Subject: RE: LU/252/21/PL - 6 Selbourne Place, Change from current 8 bedroom large house in multiple occupation (sui generis) to a 9 bedroom large house in multiple occupation (sui generis).

87.2. Planning Application LU/252/21/PL – 6 Selbourne Place, Littlehampton

Proposed Ground Floor Plan 1:50

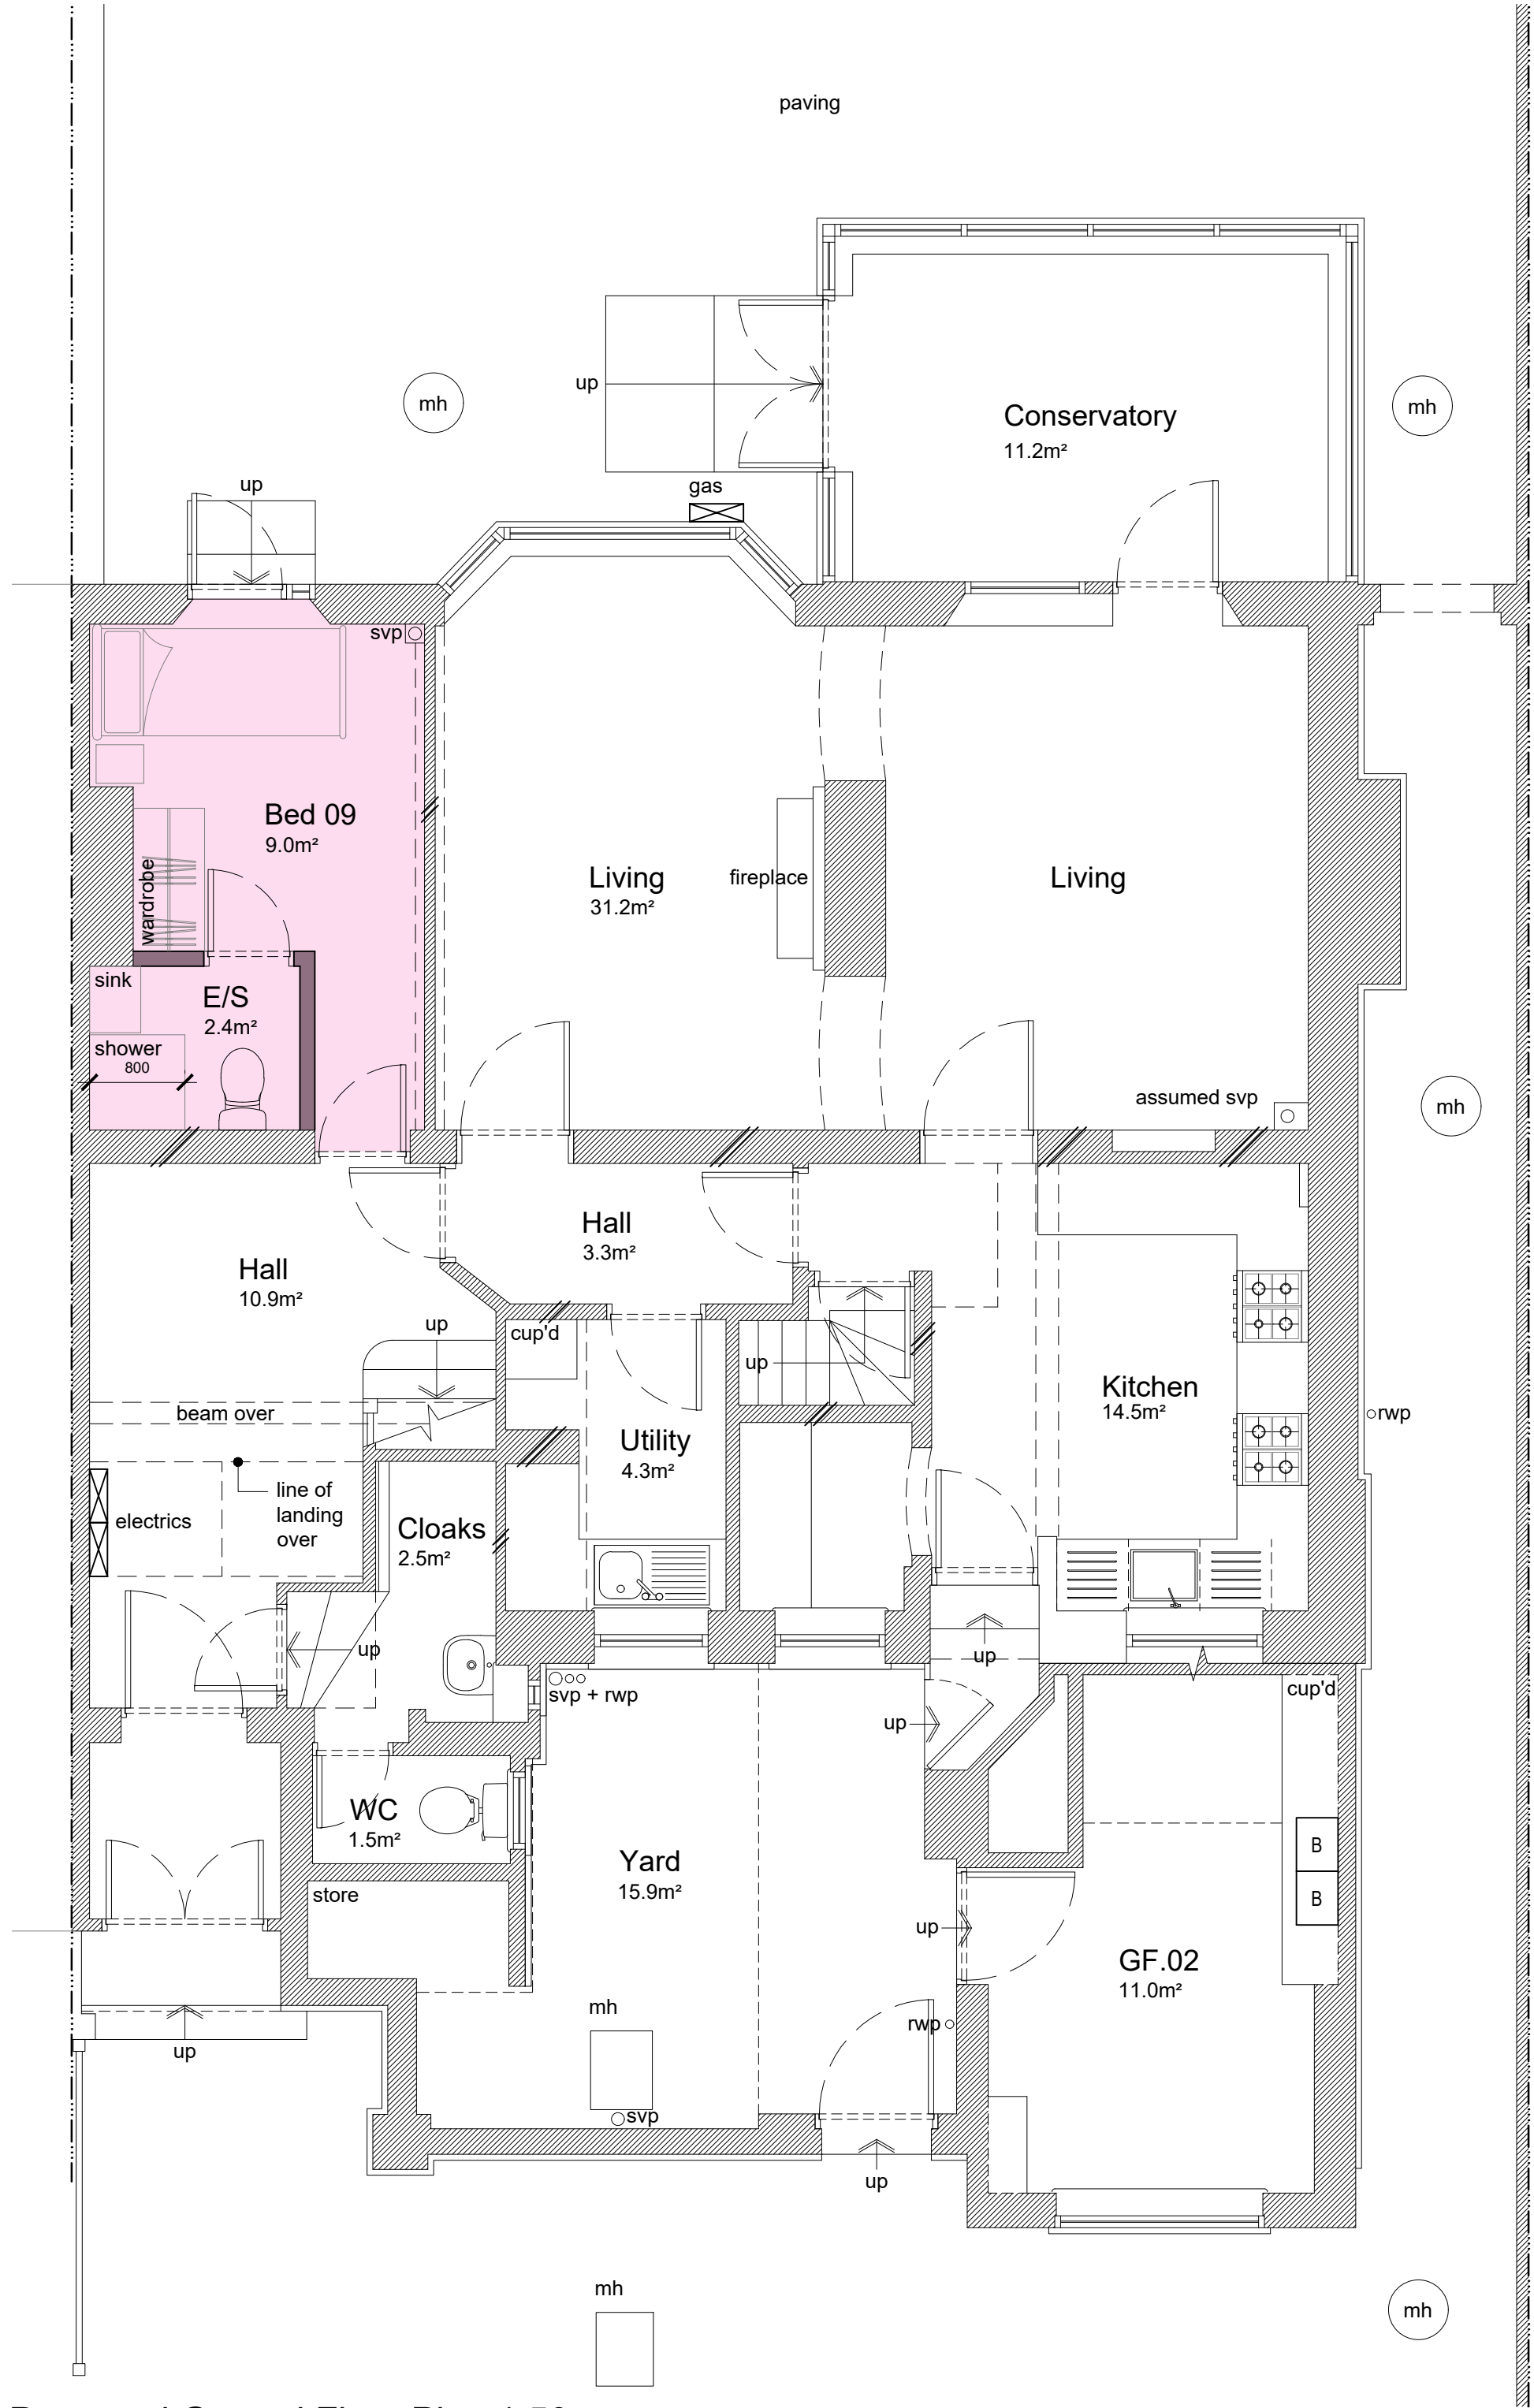
The Committee was requested to review its response to this application in light of the comments from the District Council's Houses in Multiple Occupation (HMO) Officer (previously circulated). In his response to the application, he had highlighted that whilst the accommodation did meet the minimum standards, it was still lacking in other aspects, namely bathroom provision and windows. It also showed that whilst planning could be approved, this did not guarantee that an HMO license would be granted. This emphasised the importance of engagement in the licensing process for Members of the Committee and it was agreed that this be raised with the District Council. Overall, Members still had significant concerns about the provision in relation to bathrooms and windows and the Committee therefore **RESOLVED** to:

I note the Town Council comments made in relation to the above planning application on 20-09-2021 which stated: 'These proposals were considered by the Town Council's Planning and Transportation Committee at the meeting on Monday 13th September 2021. The Town Council objects to this application on the grounds that the proposal fails to conform to the District Council's HMO Space Standards in respect of the size of the kitchen. The Standards specify that a kitchen in a property with a potential capacity of 13 residents should be 19.5m². The kitchen is 14.5m² and therefore deficient.'

With regards to the kitchen size, this would meet the minimum standards required based on a 9-bed HMO. The kitchen size referred to by the Town Council is in relation to a kitchen/diner (a kitchen which is large enough to accommodate dining facilities when there is no separate communal dining facilities available), however the property benefits from a large living room (31.2m²) which could provide separate dining facilities. Therefore, the minimum kitchen size required for 9 occupants is 13m², which this kitchen meets.
